WEST SUSSEX COUNTY COUNCIL CONSULTATION

TO:	Arun District Council FAO:Amber Willard
FROM:	WSCC - Highways Authority
DATE:	24 January 2022
LOCATION:	Land at Rustington Retail Park New Road Rustington BN16 3RT
SUBJECT:	R/298/21/PL Erection of a drive-thru coffee shop (Use Class E) with associated parking, service arrangement, landscaping and associated infrastructure. This application is in CIL Zone 4 (zero rated) as other development.
DATE OF SITE VISIT:	n/a
RECOMMENDATION:	Modification
S106 CONTRIBUTION TOTAL:	n/a

Proposed Site Layout

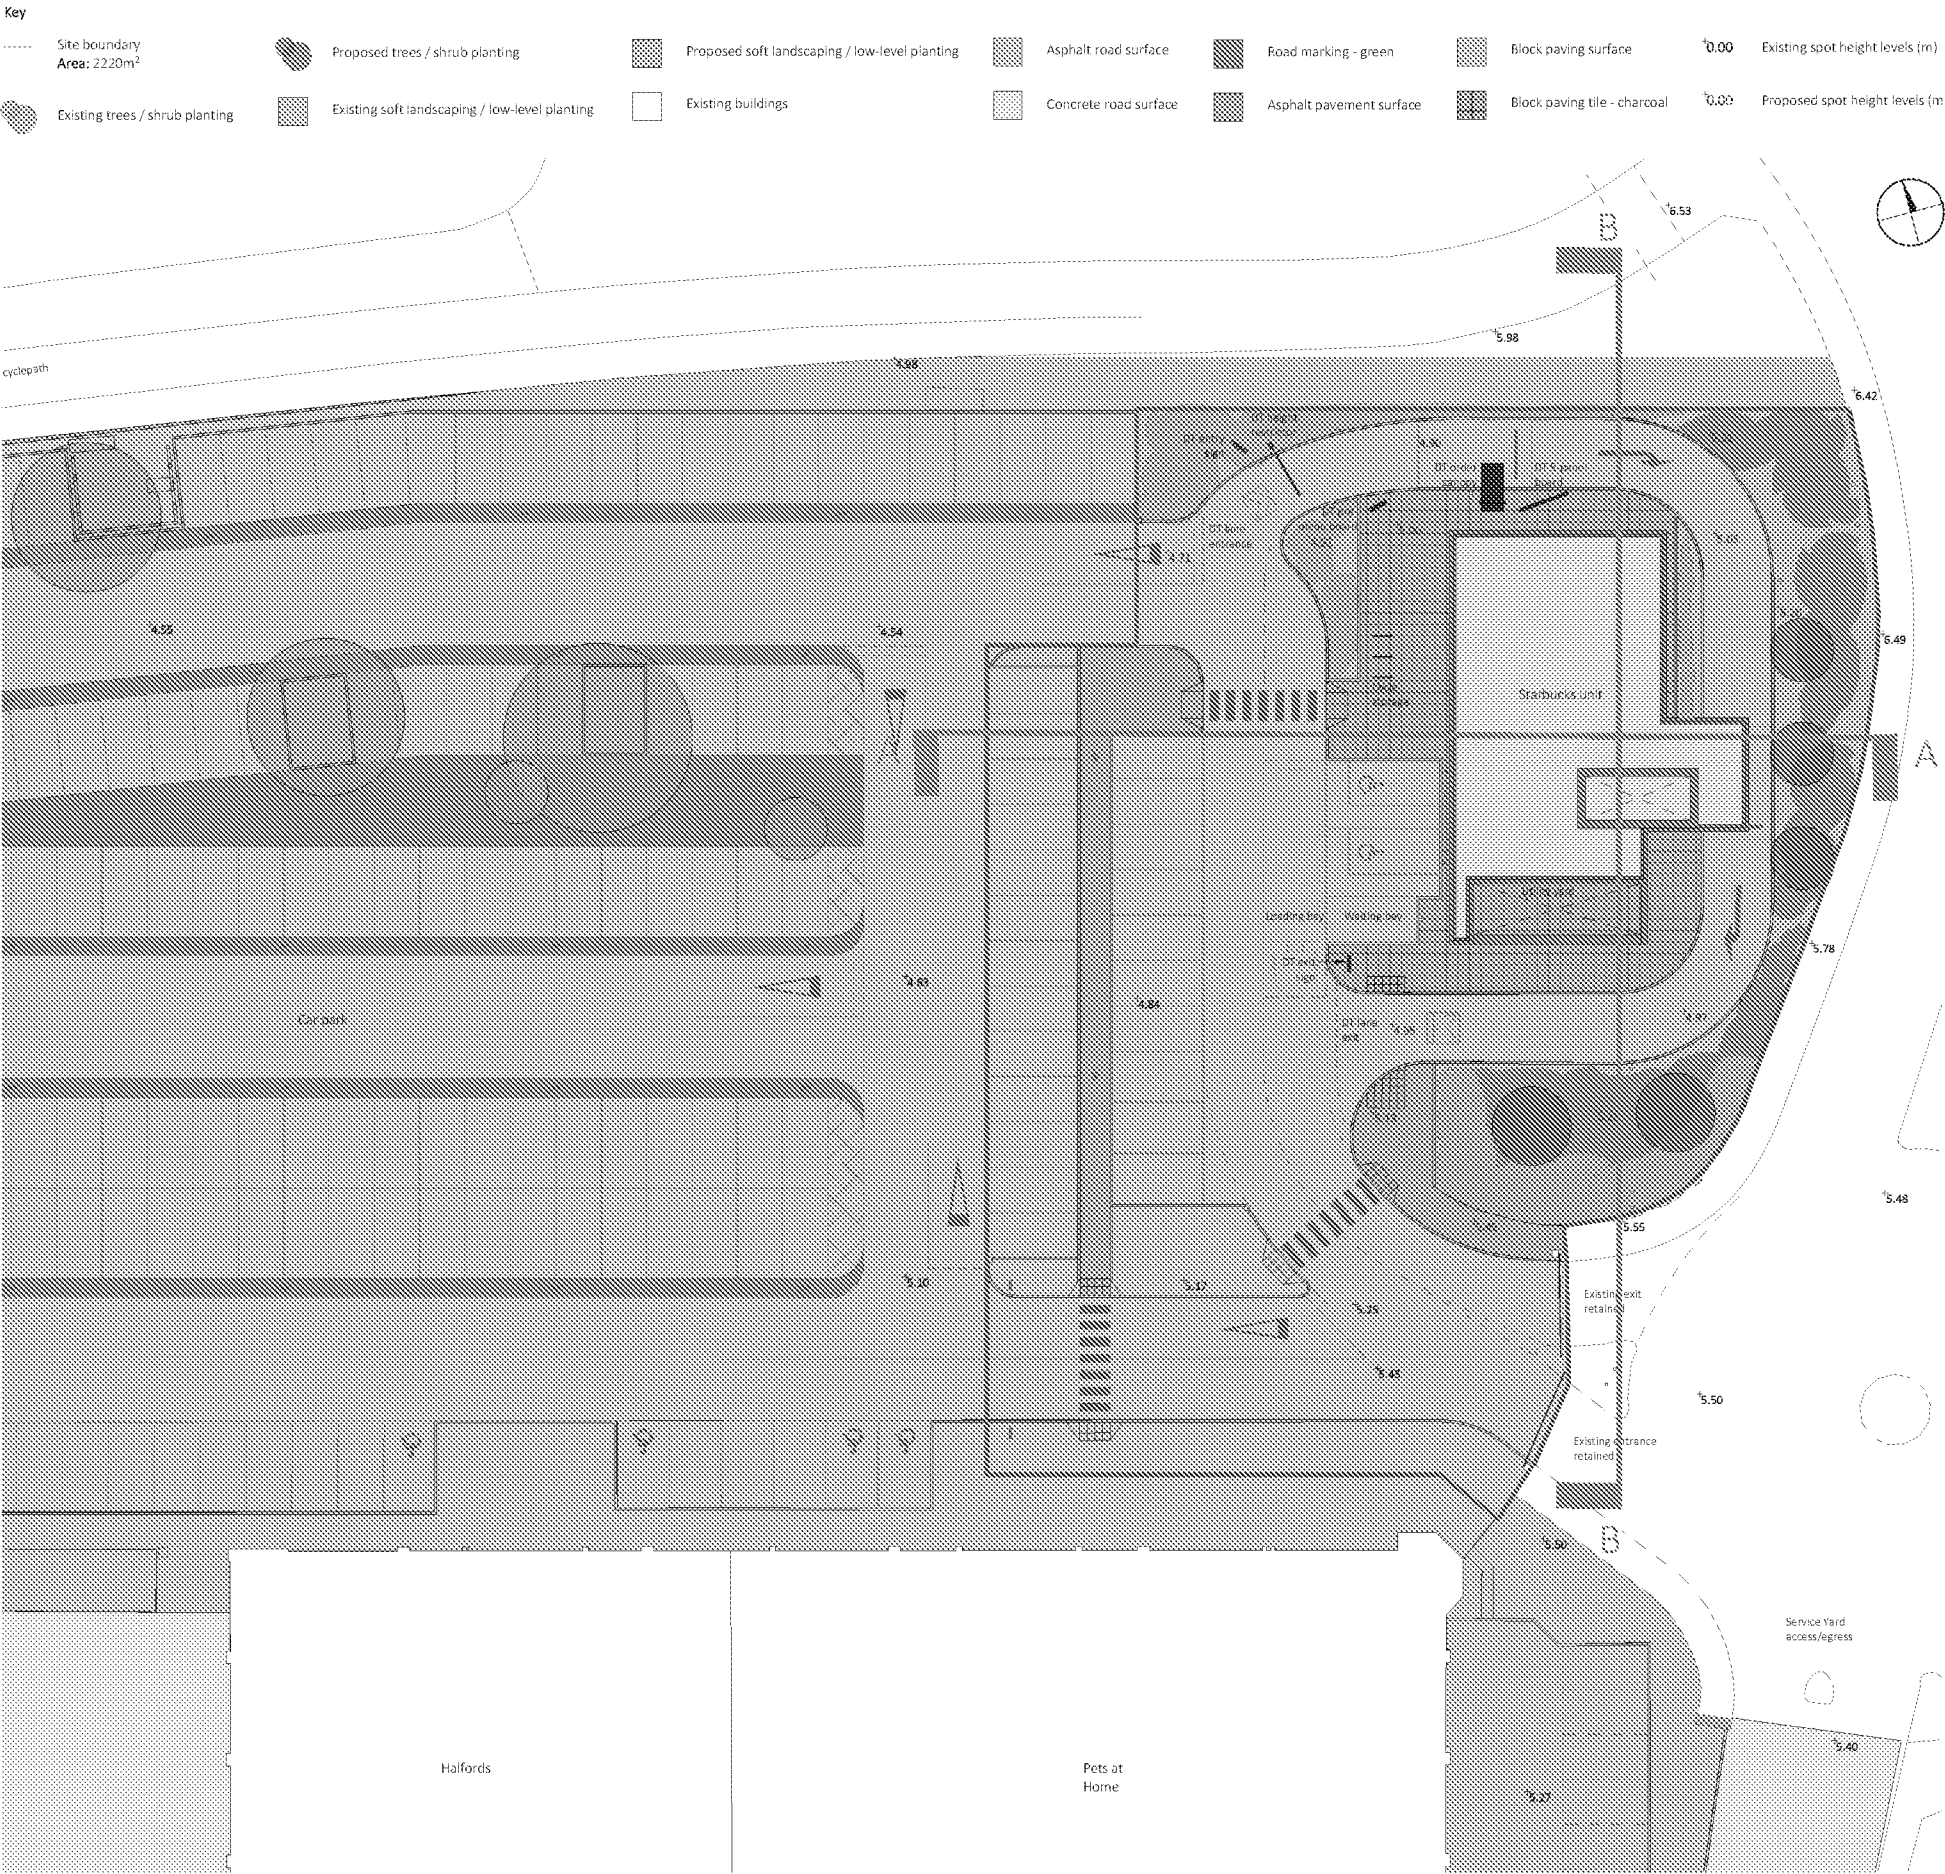
However the suitability of the access immediately on the exit/entry onto the Rustington Retail Park roundabout would be questioned. As shown, the proposed arrangement gives priority to vehicles entering and exiting the proposed use. Given the various existing commercial units would be expected to generate significantly more vehicle movements compared with the proposed use, it seems very unusual to have the low trafficked, minor arm access exerting a priority over the dominant traffic flow. The access is also extremely close to the entry/exit to the existing Rustington Retail Park roundabout leading to potentially confusing vehicle movements.

Whilst recognised that the access arrangements are within private land, it is recommended that this is revised. There seems no reason for example, why an entry and exit is required into the proposed development immediately after the Rustington Retail Park roundabout. Seemingly, an exit only arrangement would appear appropriate with vehicles exiting the development having to give way to traffic resulting from other existing developments. Entry to the development would then be via the car park as presently shown.

In summary, the only concern with the proposal are with respects to the vehicular access arrangement, specifically the new entry/exit on the immediate exit/entry from the Rustington Retail Roundabout. The access arrangement should be revised.
